GREAT DIAMOND
ISLAND SHORES
SOB.D. (1976) - DAVID
ELLIOT

CITY OF PORTLAND, MAINE
PLANNING BOARD

LIST OF RECOMMENDED CHANGES
TO THE FINAL PLAT FOR
GREAT DIAMOND SHORES, PHASE I

TO: Warren J. Turner, Planning Department
FROM: John P. Rague, Department of Public Works
SUBJECT: Review of Final Plat for Ct. Diamond Shores Subdivision

LOT #17

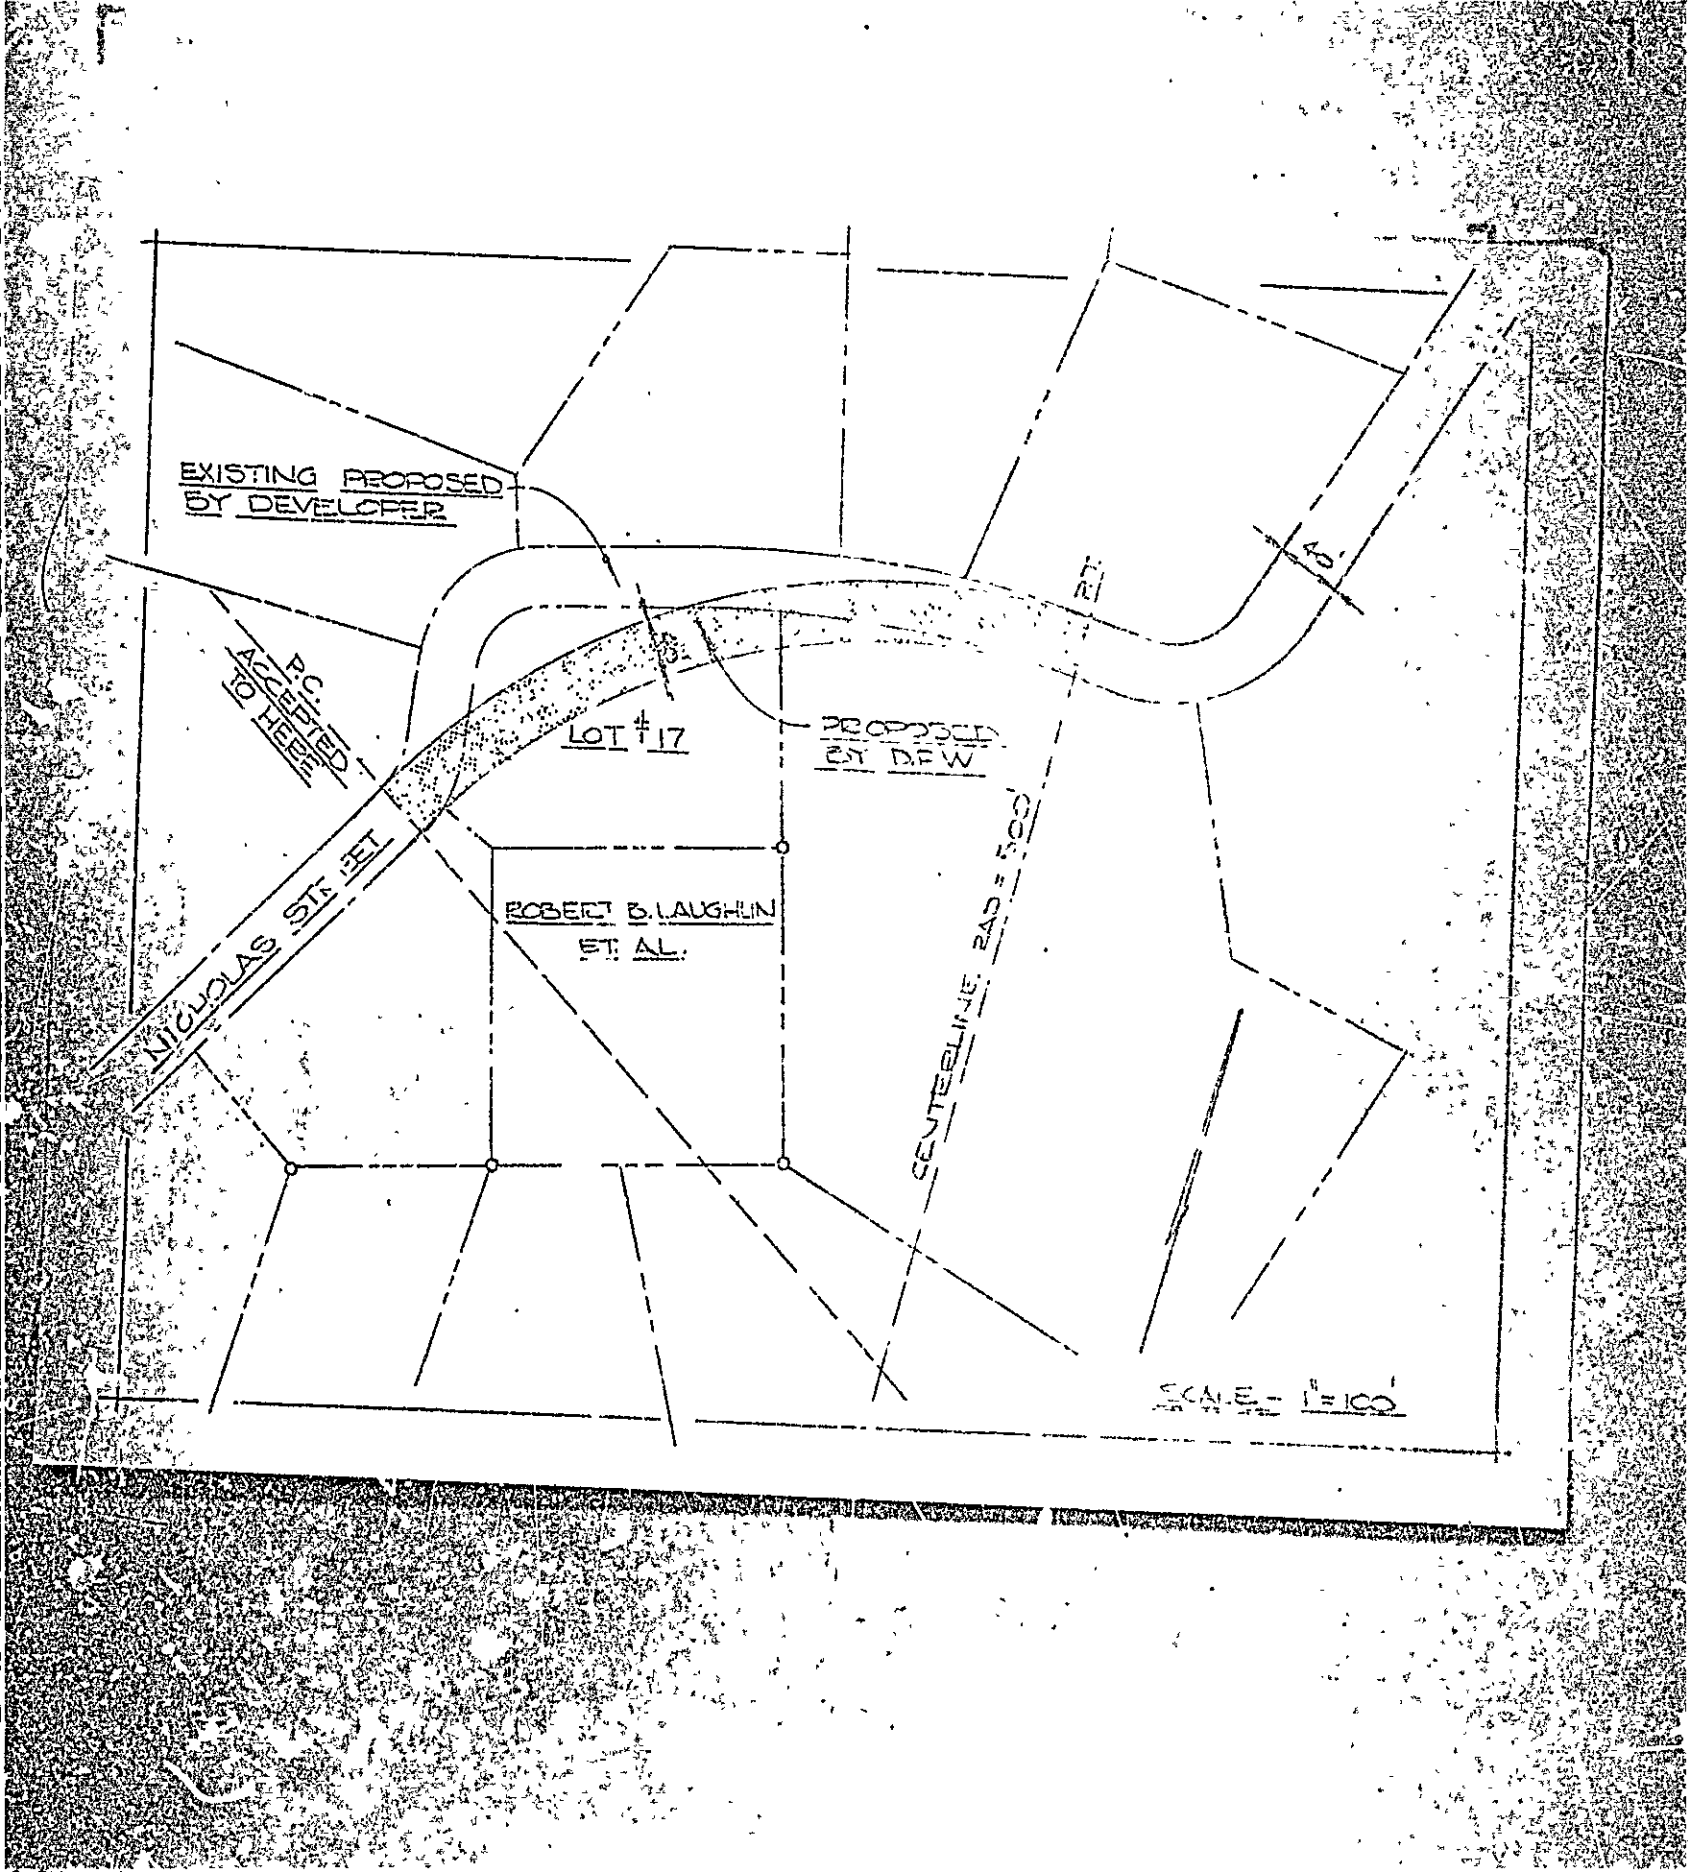
The proposed alignment of Sunset Avenue Extension appears to be quite prohibitive to proper vehicular turning movements. This Department would recommend that such proposed alignment be changed as shown on the attached sketch.

Review of the proposed realignment, which the developer was proposing, calls for a right angle turn in the road. After some review it was decided that the developer would revise his plan to realign the proposed street in order that a smooth alignment would be realized.
